Date: 09/18/2025

Re: Inspection Items
Location: Lot 102 Kipling Village (188 South Breeze Way. Fuquay-Varina, NC)
JDS Project No.: RDU2509756
Date of Inspection: 09/18/25

1 FOUNDATION HOLD DOWN DETAIL
 NC-4 SCALE: 1/4" = 1'-0"

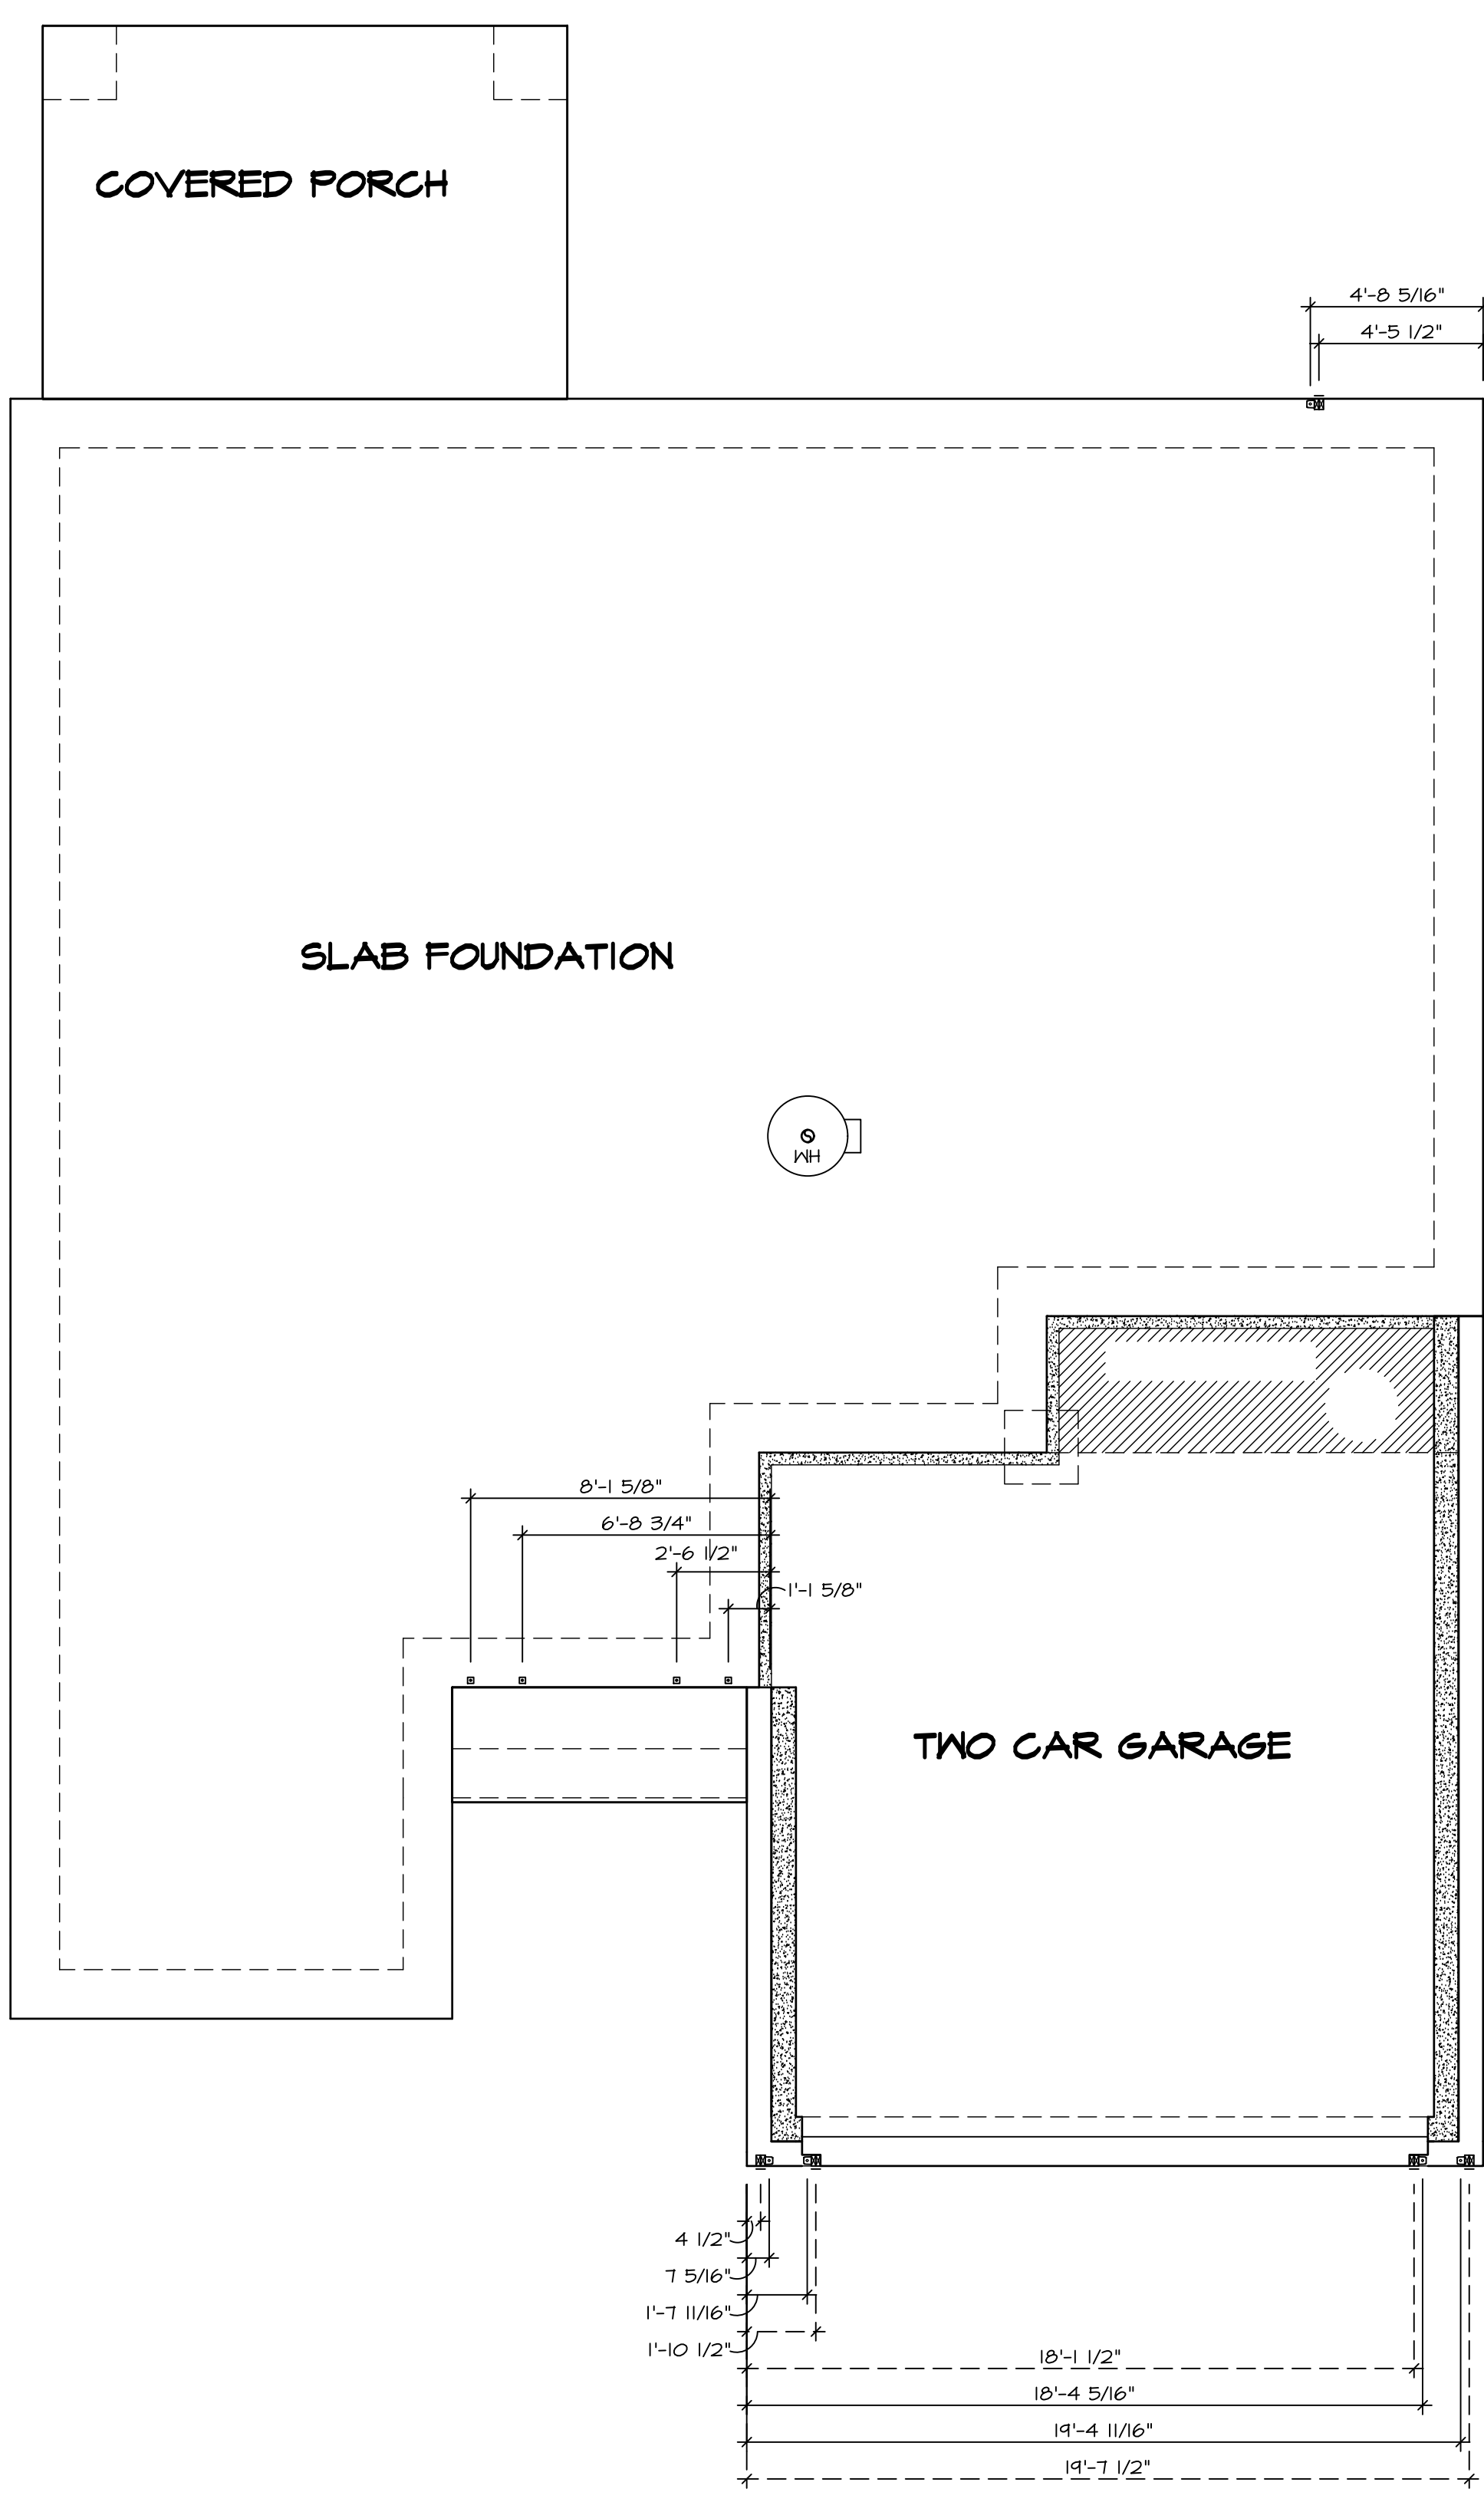
1. The left wing wall has an anchor bolt blowout at the front face of the inside right-most hold-down.
2. The right-wing wall has what appears to be a cold joint at the left end of the wall.
3. The front garage wall at the right garage wing wall was called out by the inspector for an overhanging 2x4 sill plate. The sill plate was measured to be overhanging approximately 1/8" to 3/8".
4. The inspector is questioning the hanger gaps at the roof trusses above the front left room. The maximum hanger gap that was observed was approximately 1/2". HUS26 hangers were installed.

1. Cut out the damaged portion of the wing wall back to the wider portion.
 - a. Dowel (2) equally spaced #4 rebar into the mid-depth of the cut face of the wingwall with a minimum 4" embedment with a minimum 4" of projection

- b. Dowel (1) equally spaced vertical #4 rebar into the left-to-right length of the repair area with min. 4" embedment and 3.25" projection. Tie the horizontal and vertical rebar together. Ensure all rebar has a minimum of 2" concrete clear cover on all sides.

- c. Clean all dowel holes with compressed air and/or a wire brush prior to rebar installation and epoxy injection. Inject enough 2-part structural epoxy into the holes to create squeeze-out upon rebar installation.

- d. **Contact JDS Consulting for inspection before pouring a minimum of 3000 psi concrete.**
2. Cut the parged portion of the wing wall back to the wider portion.
